29/11/2021

New Liverpool Primary School (SSD-10391)

Request for additional information

Drawing Title
SITE PLAN - PROPOSED

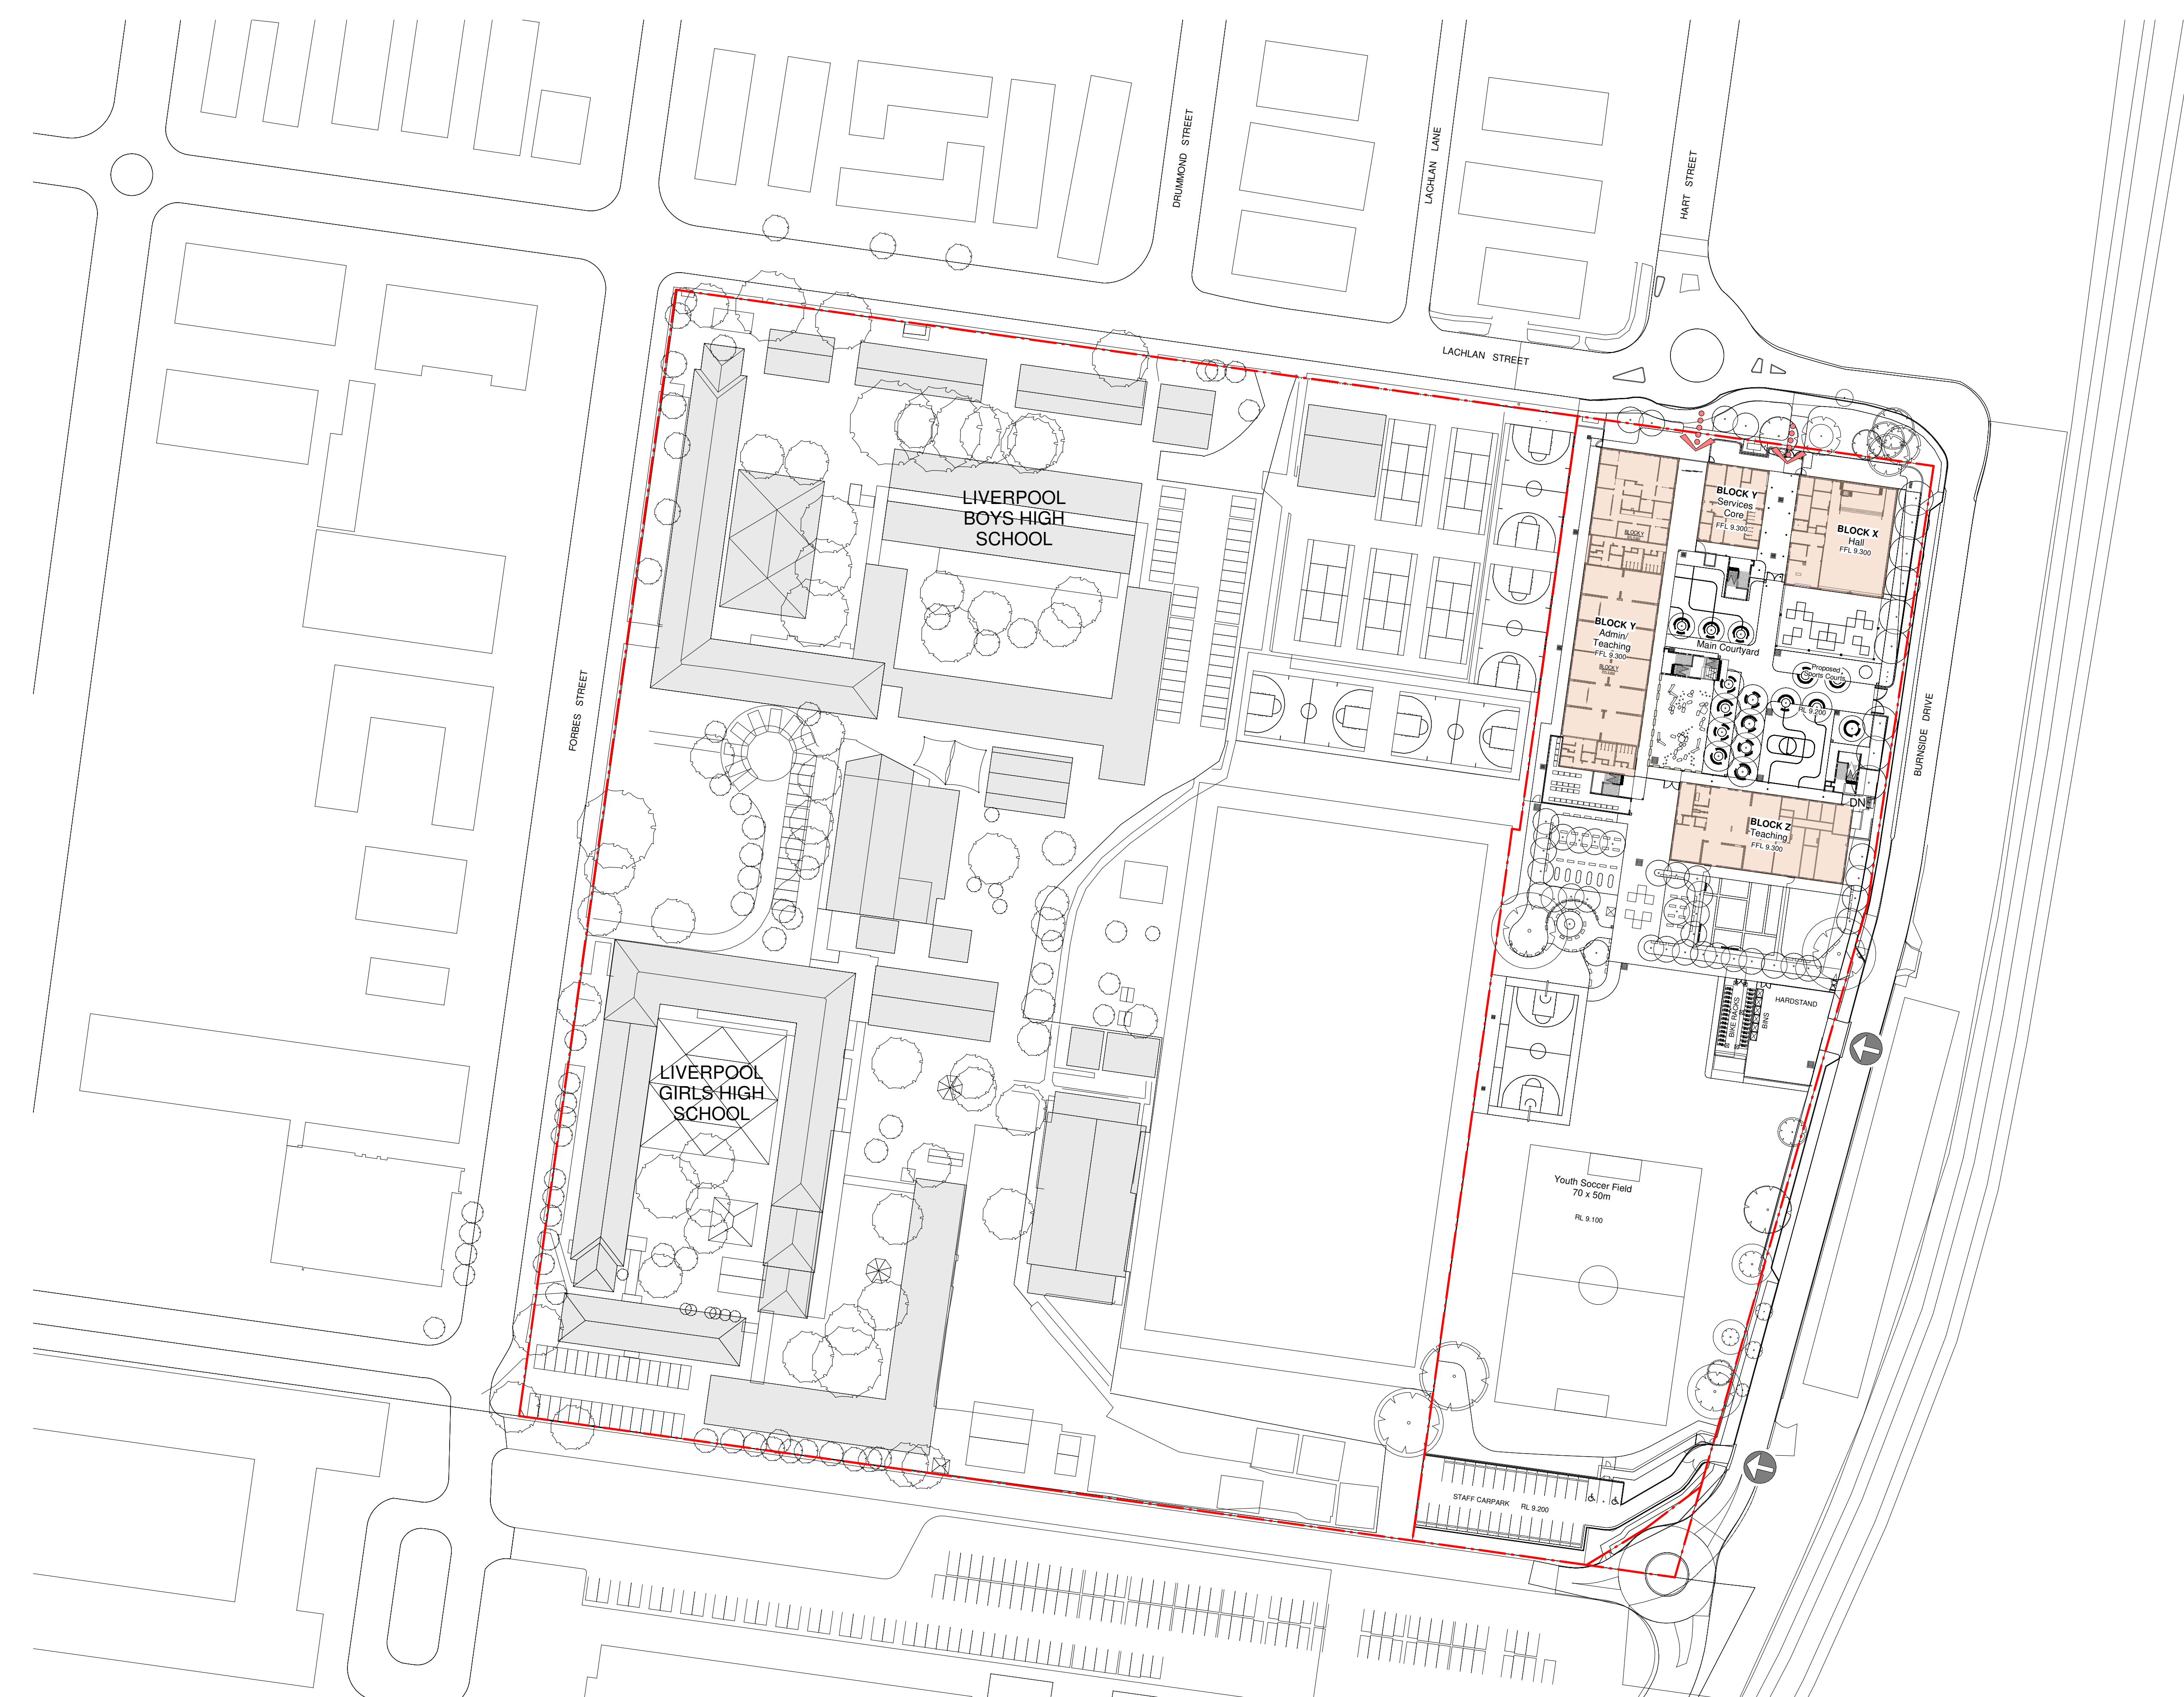
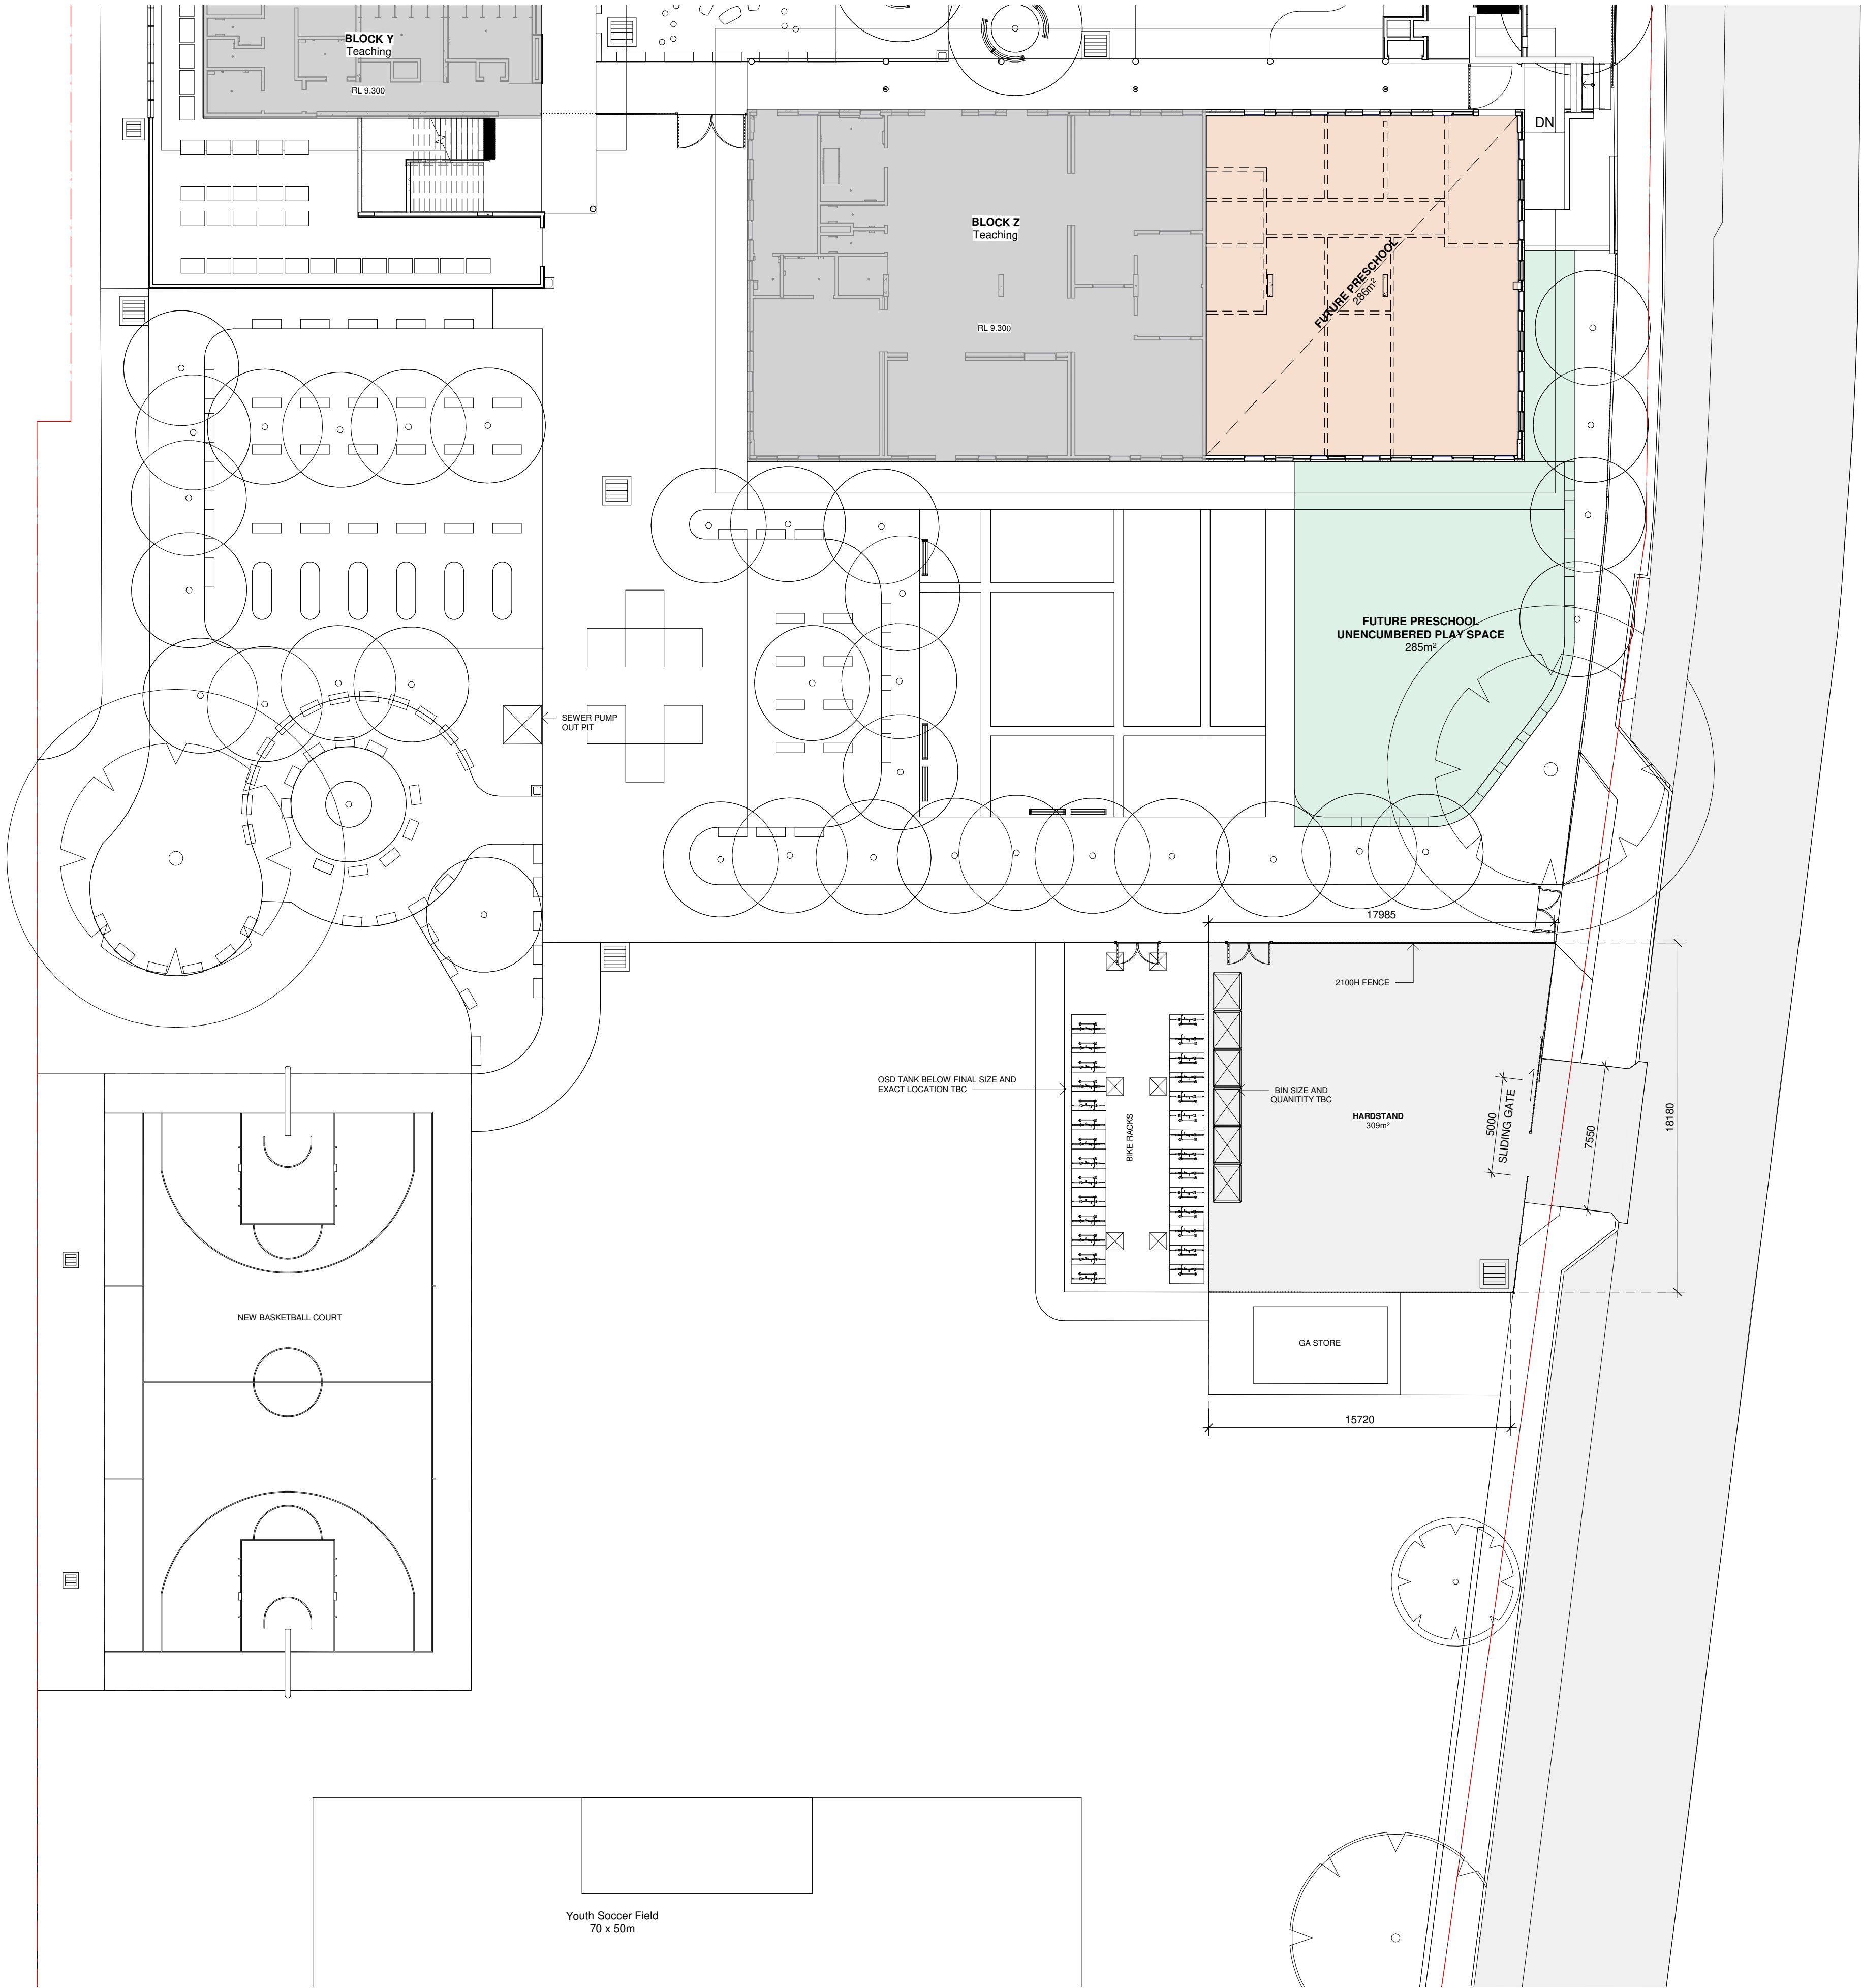
3. The location of the trees in the submitted drawings NLPS-AR-DRG-SSD-0202 and NLPS-LA-SD-0101-DRG(05) are inconsistent. Please submit consistent landscape and architectural plans.

4. The RTS states that the proposal has been amended to reduce the setback of the Lachlan Street entry link (L1 and L2) . However, the RTS documents do not identify the amount of reduction and any resultant effect on the streetscape and/or change to the elevations. Please address this issue and submit amended plans, where needed.

Drawing Title
OVERALL GROUND FLOOR PLAN

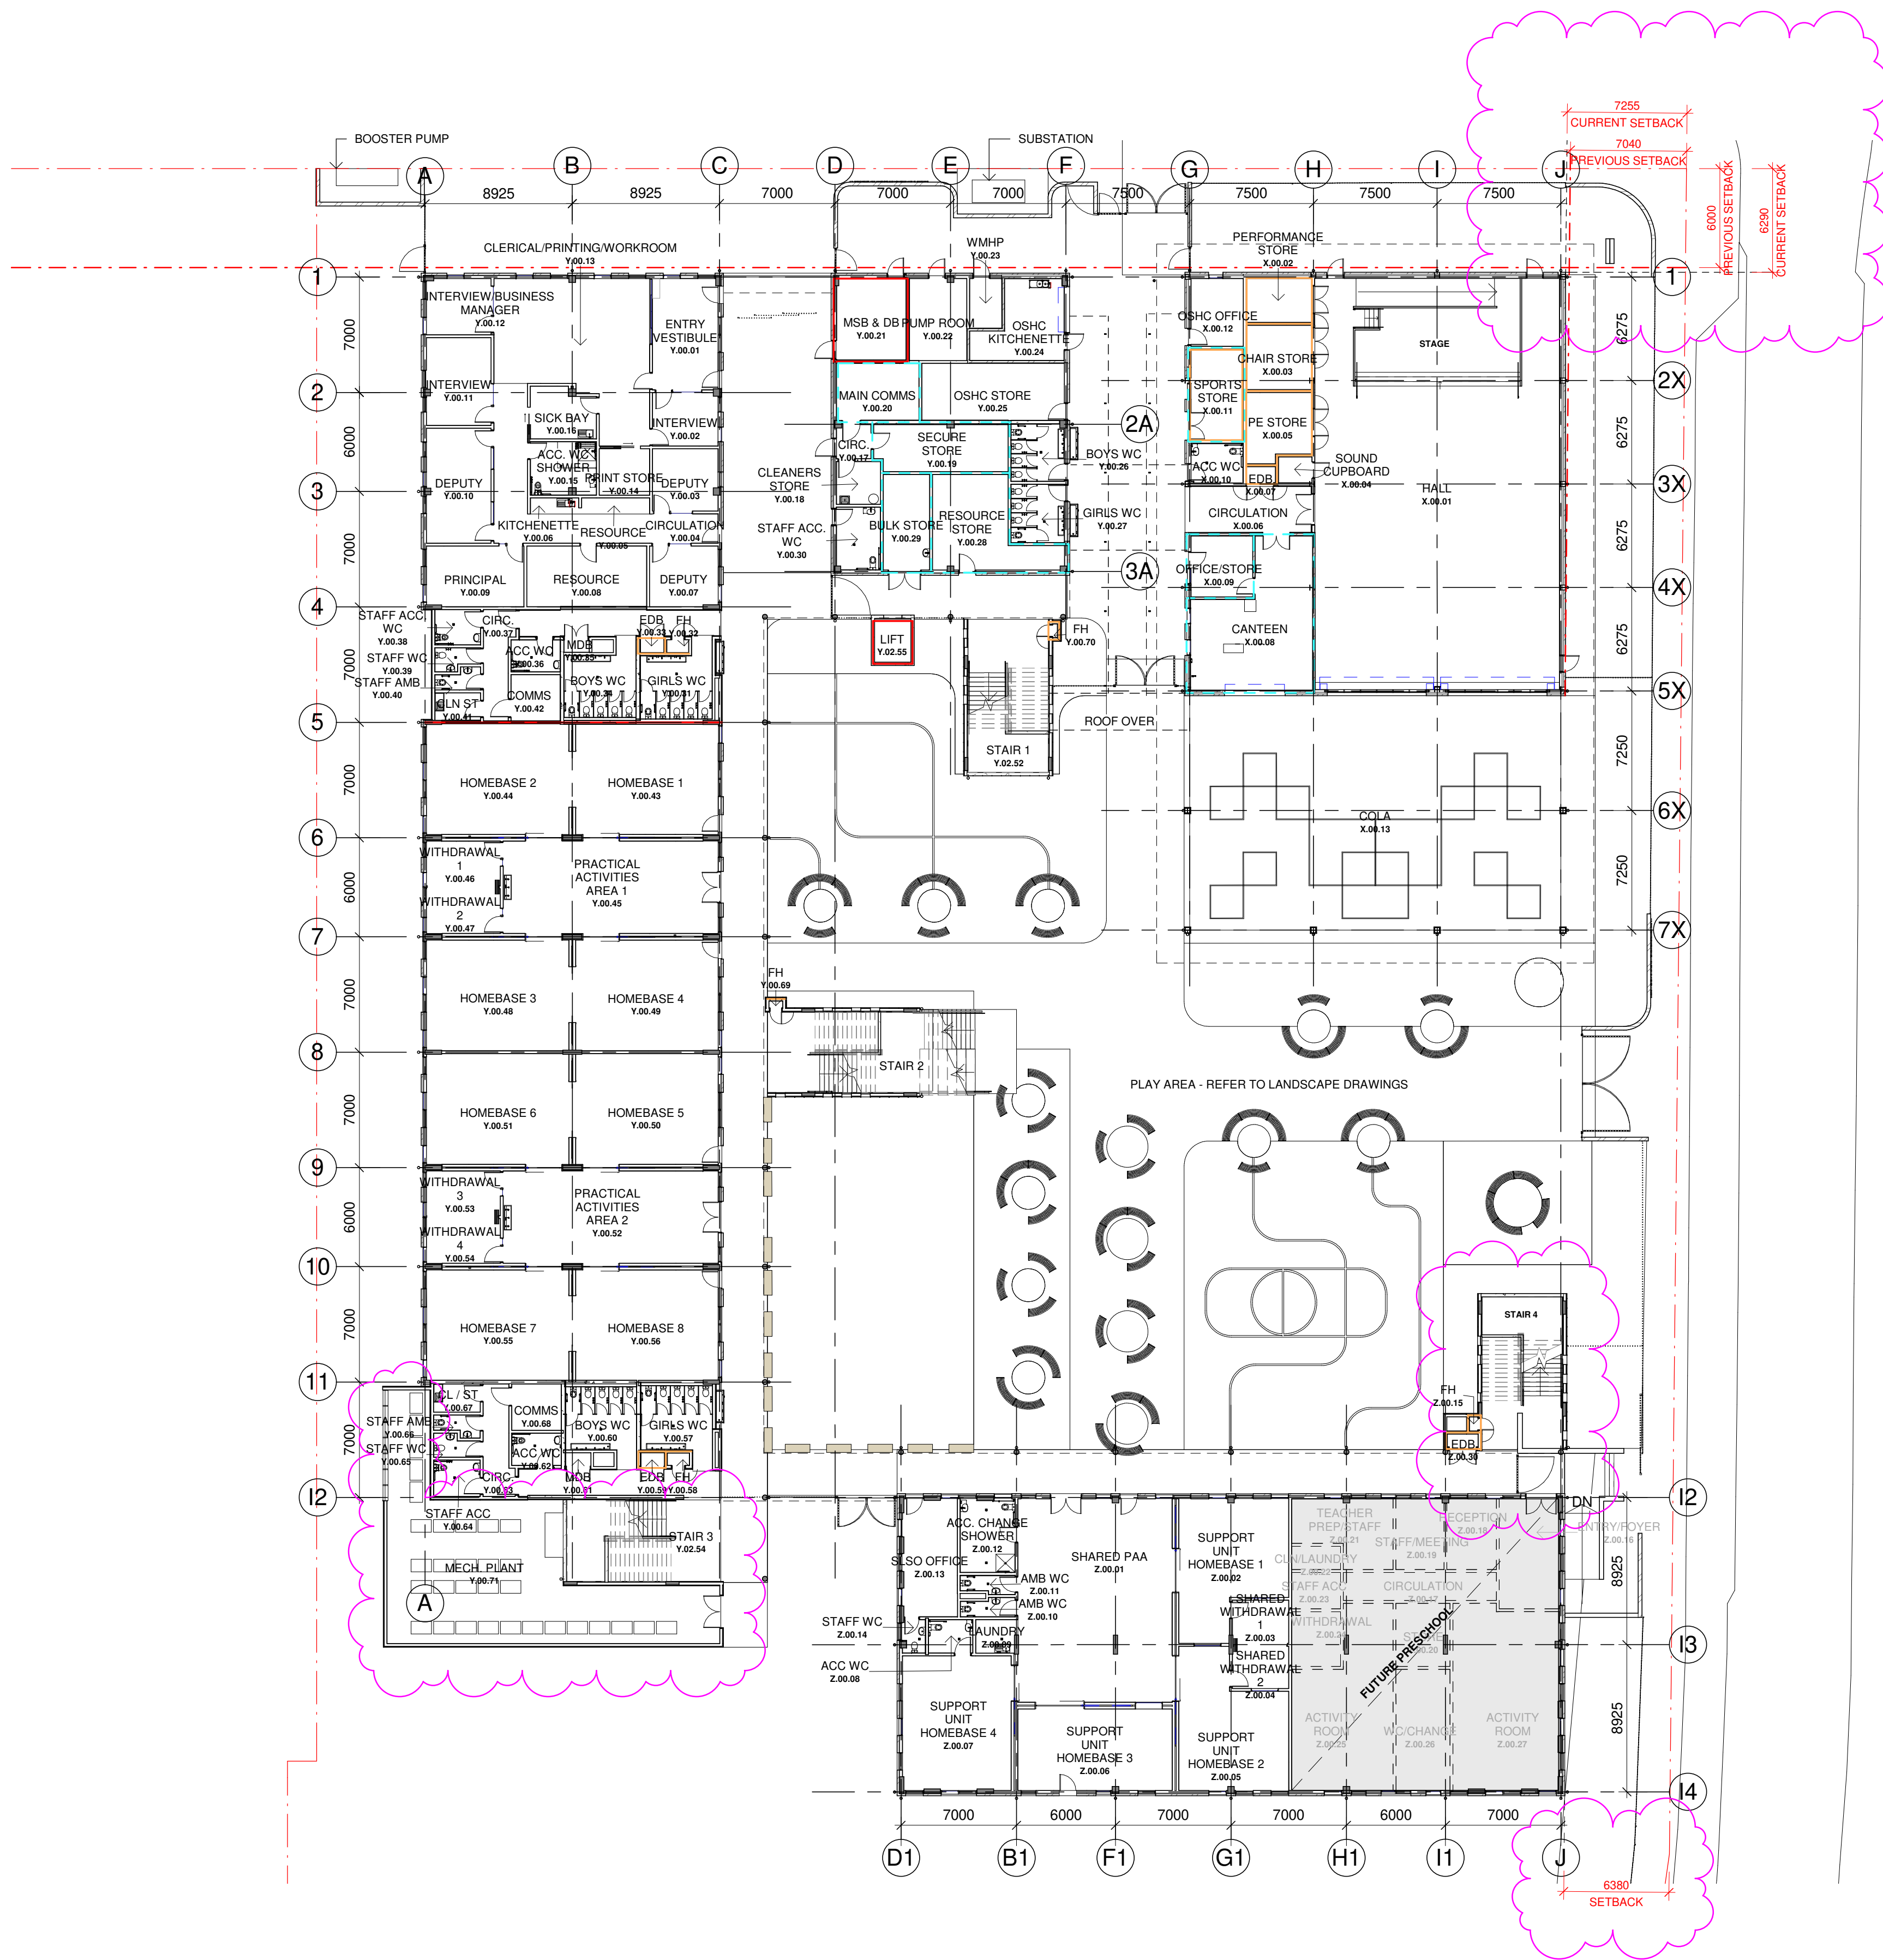
1. The RTS indicates that approval is requested for the shell space of the preschool. This is not considered acceptable. The Department's childcare guidelines require that the unencumbered indoor play area for child care centres (such as the proposed preschool) comply with certain criteria. Compliance with this criteria cannot be ascertained if the details of internal layout is not provided. Please submit amended plans with the internal layout to demonstrate compliance with the required unencumbered play area for 40 preschool children.

14. The areas and dimension for waste storage should be shown on the architectural plans.
15. The Government Architect NSW (GANSW) have reviewed the RTS and raised several pending concerns regarding the design. These concerns and requested information are listed below:
